Our Ref: FP/45/26/NMA

**Section 96A of the Town & Country Planning Act 1990 (as amended)
Town and Country Planning (Development Management Procedure) (England) Order 2015
(as amended) - Article 10**

Non material amendment following the grant of FP/137/25/HH relating to removal of dummy roof pitch, alterations to internal layout to include garage storage area and door, changes to doors and windows.

13 Bereweke Road Felpham PO22 7EG

Project Proposed plans	Sheet 2
Date 7th April 2026	
Scale 1: 50 & 1: 100

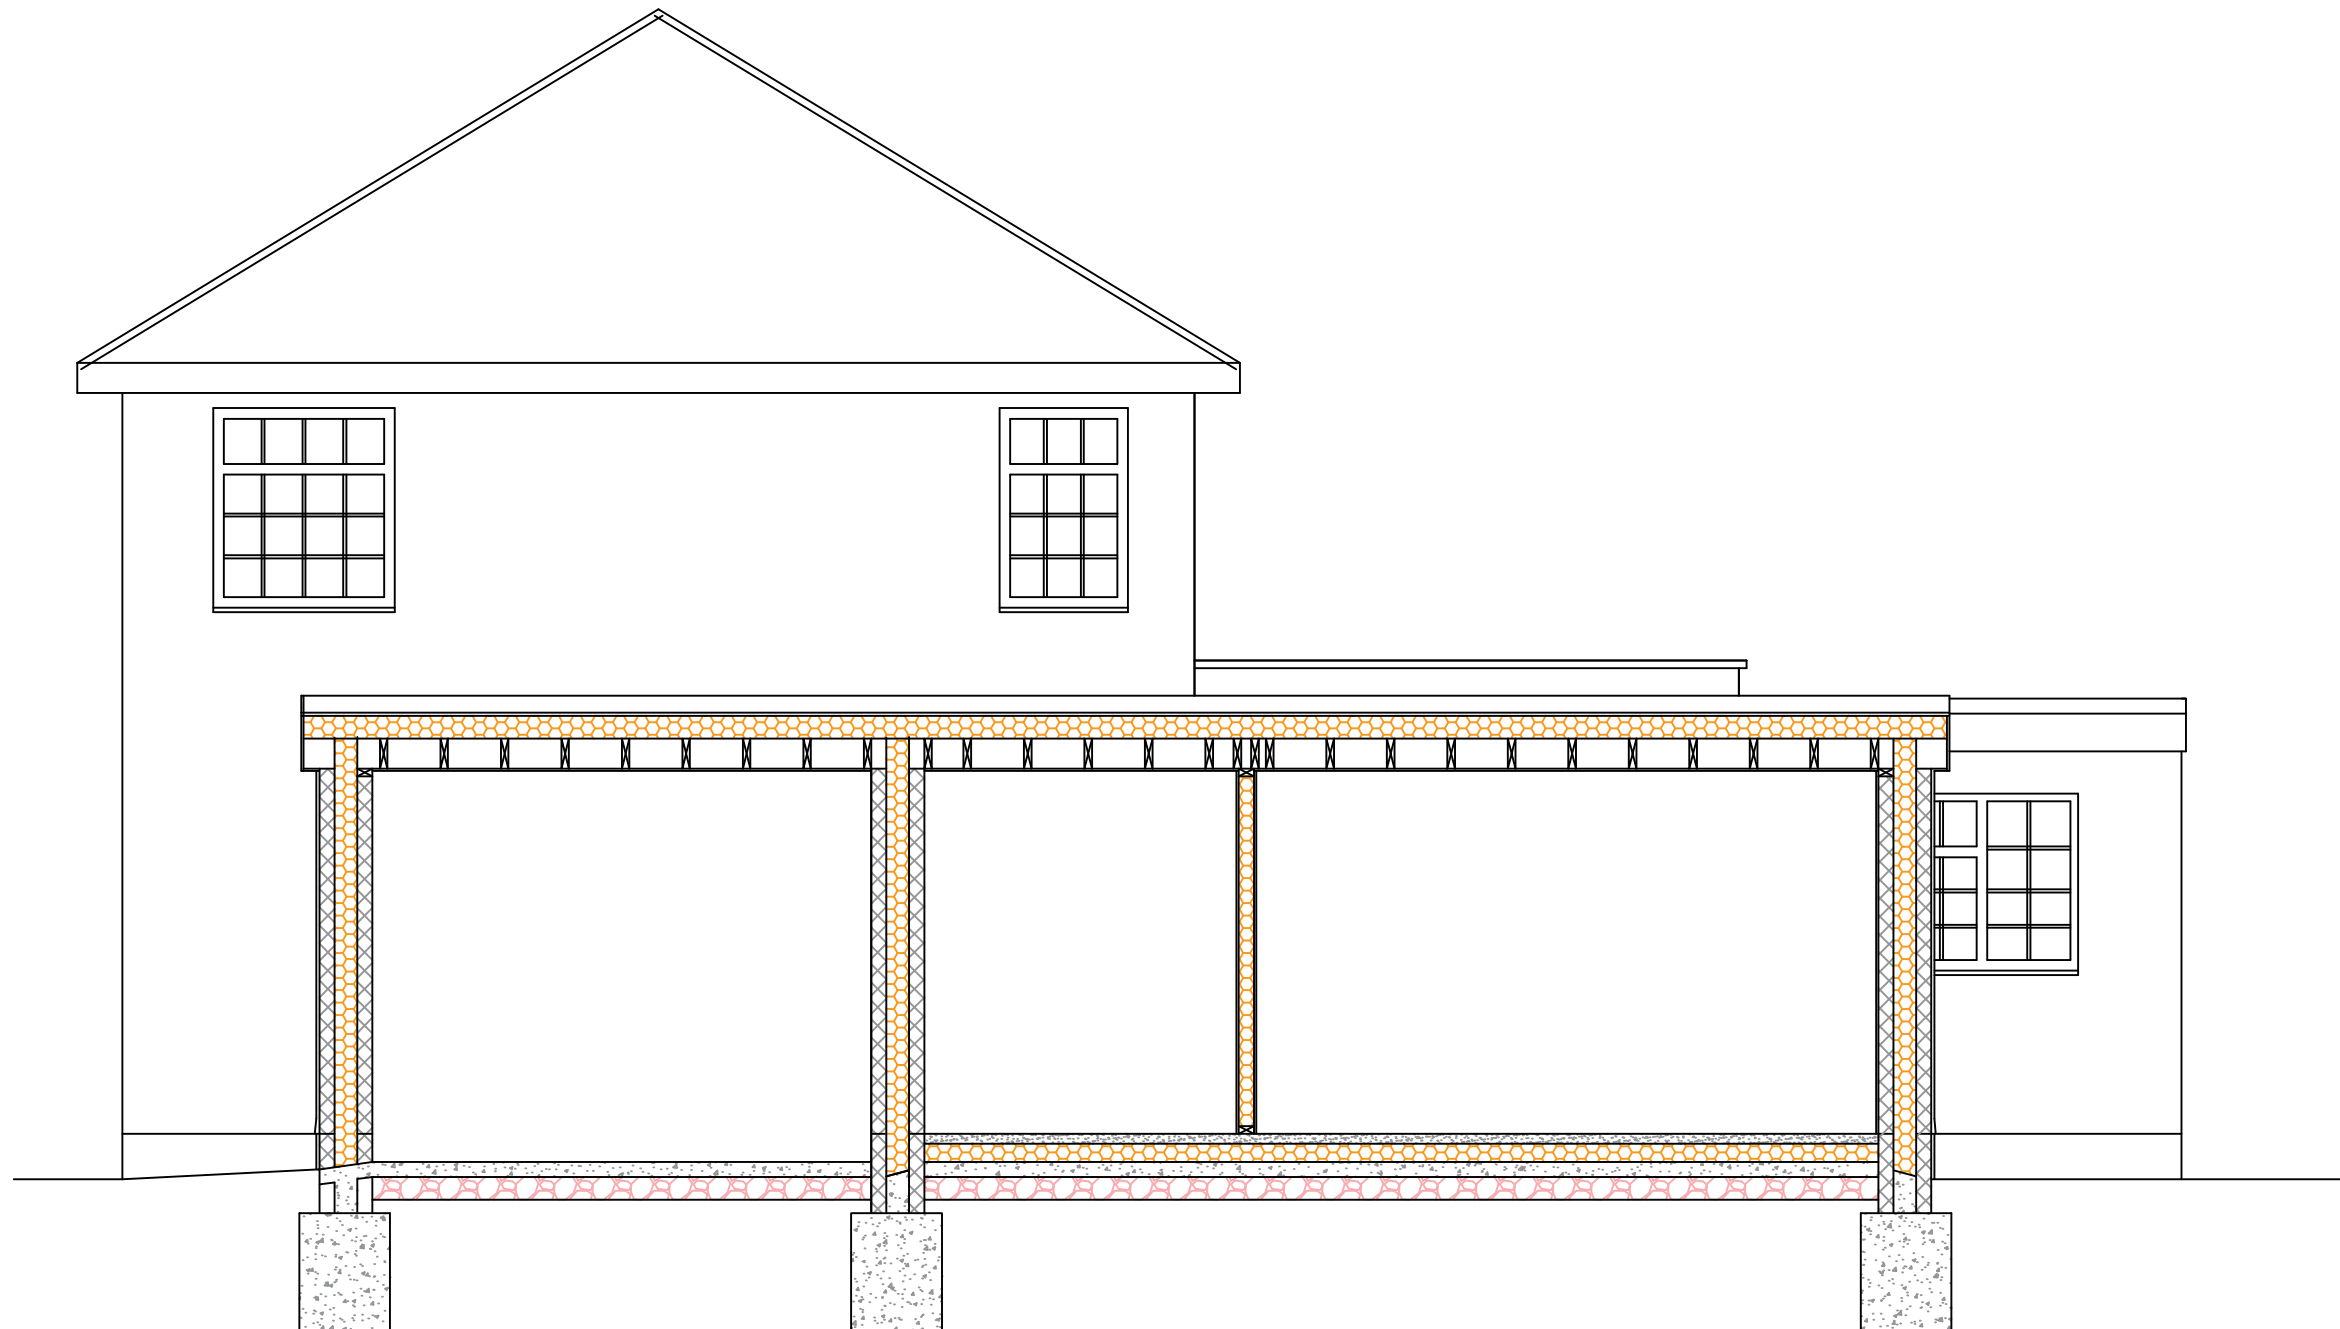
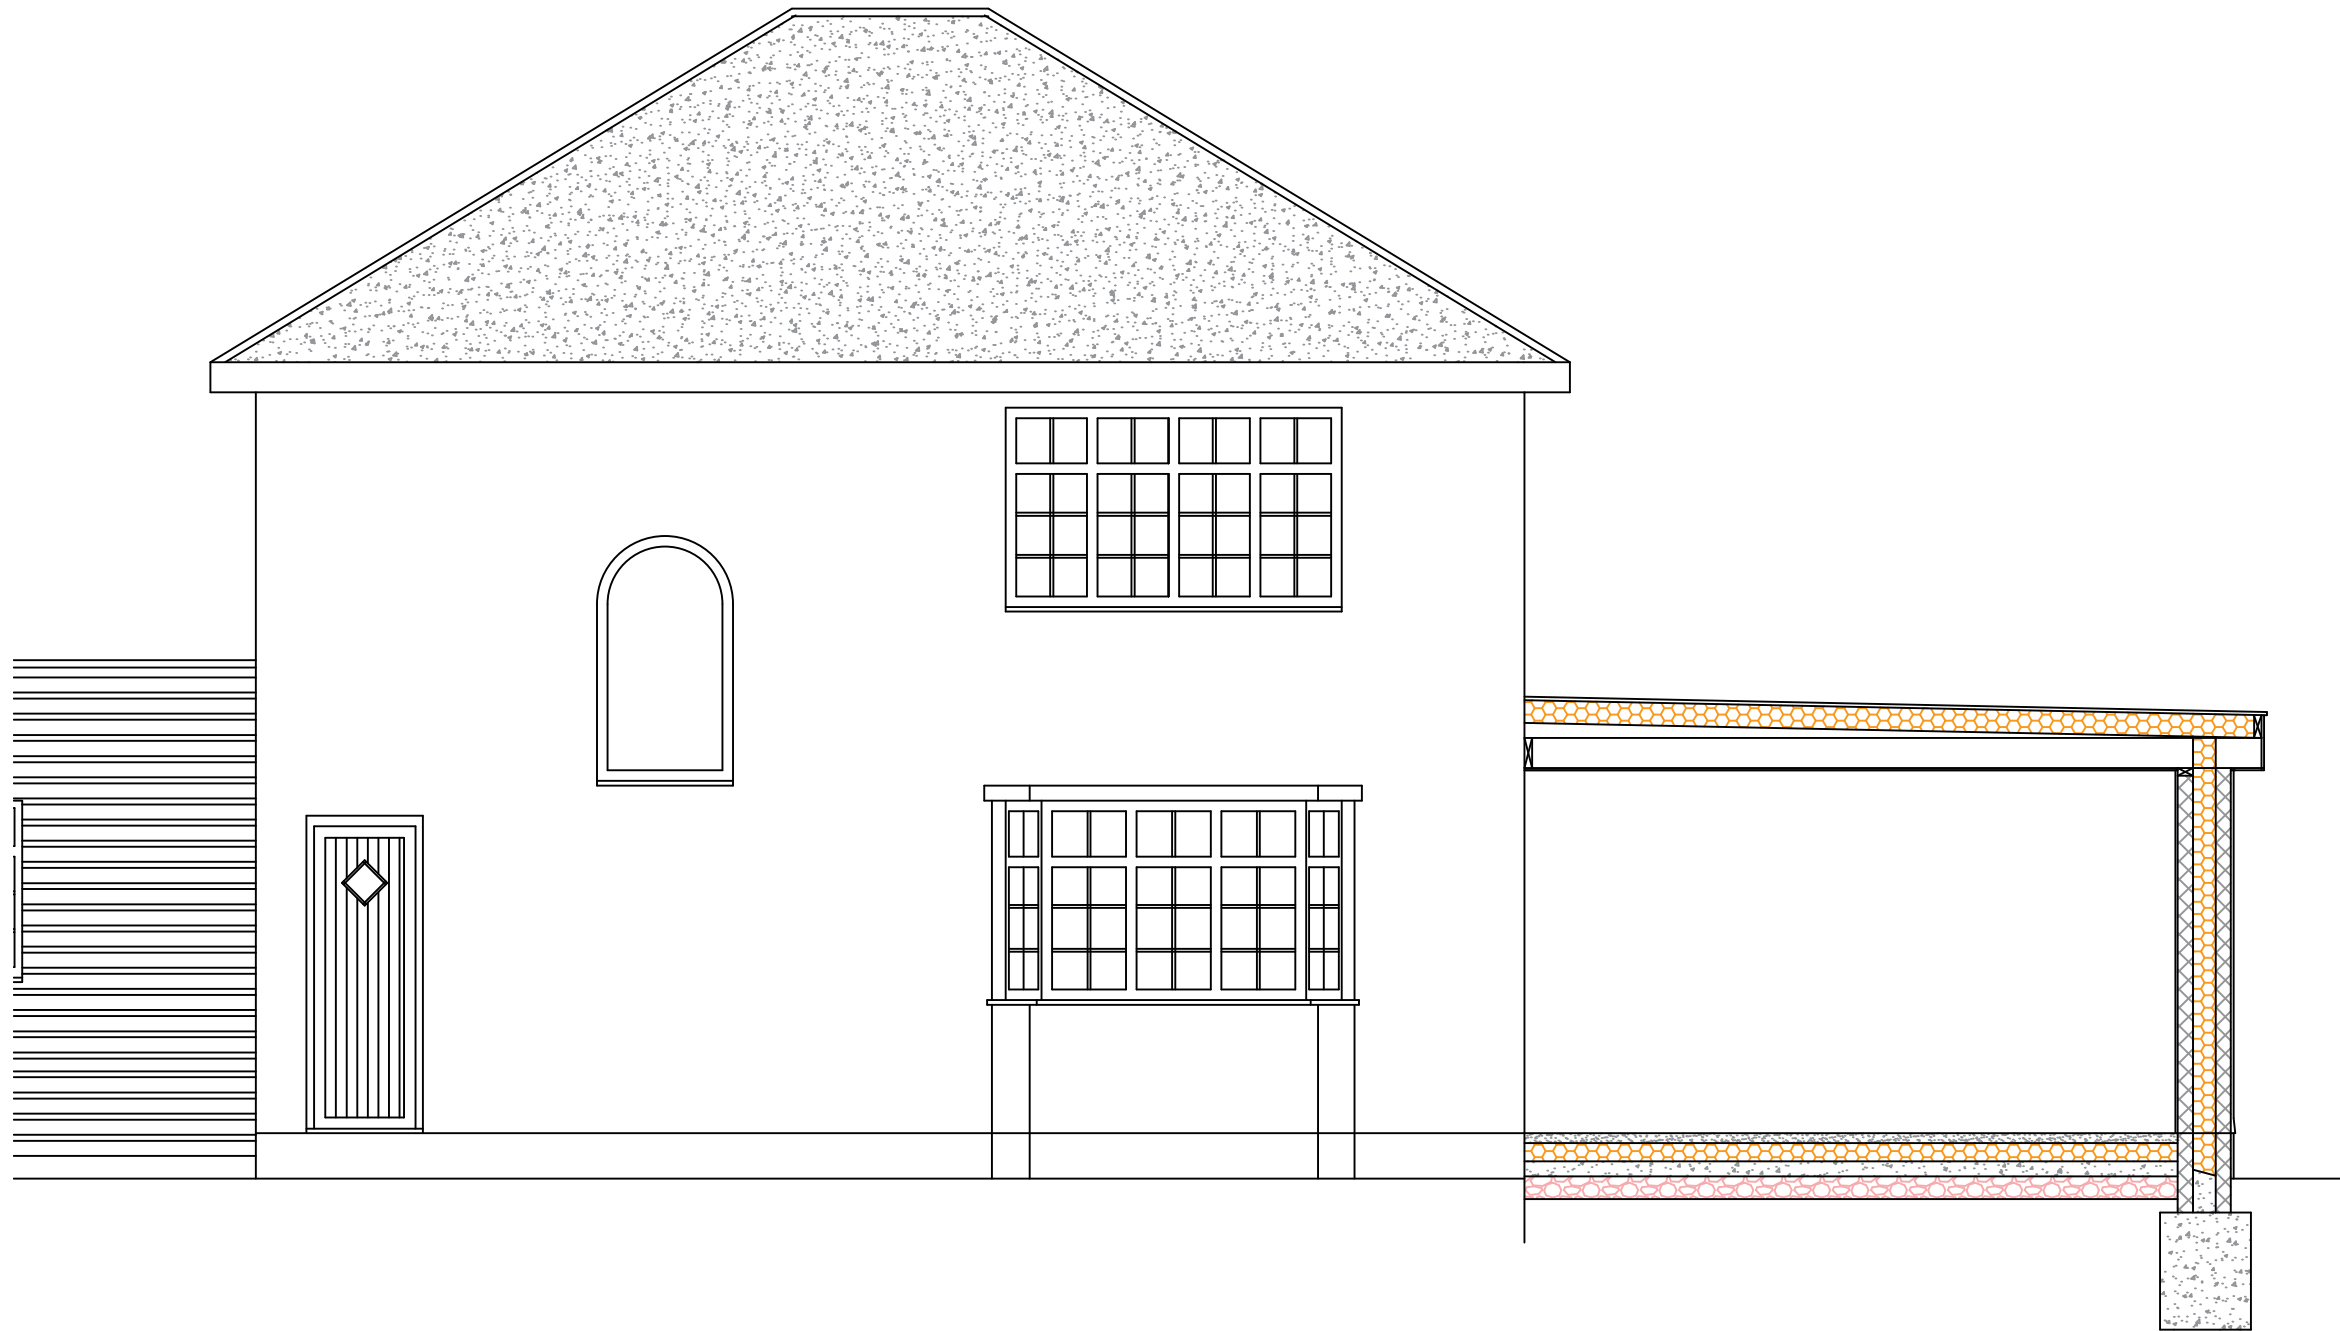
The proposal has been accepted as a Non-Material Amendment because it would reduce the maximum depth and width of the side single storey extension of the development and would not increase overlooking of neighbouring properties and it can therefore be considered under Section 96A of the Town and Country Planning Act 1990.

The proposal seeks to substitute the approved render and tiles with Marley Eternit cladding in Silver Grey C51 and to cover the mono-pitch roof with Ethylene Propylene Diene Monomer in black, with white soffits and fascia. The cladding would be in keeping with the colour palette of the host dwelling's existing render and would reflect the appearance of neighbouring properties which feature cladding in similar tones and colours. The changes are therefore considered to be minor in nature and can be determined as an NMA under section 96A of the Town and Country Planning Act 1990.

The following plans are now omitted from Condition 2:

- Proposed Ground Floor Plan 02.
- Proposed Elevations 05.

and replaced with the following amended plan:

- Proposed Plans and Elevation dated 07/04/26.
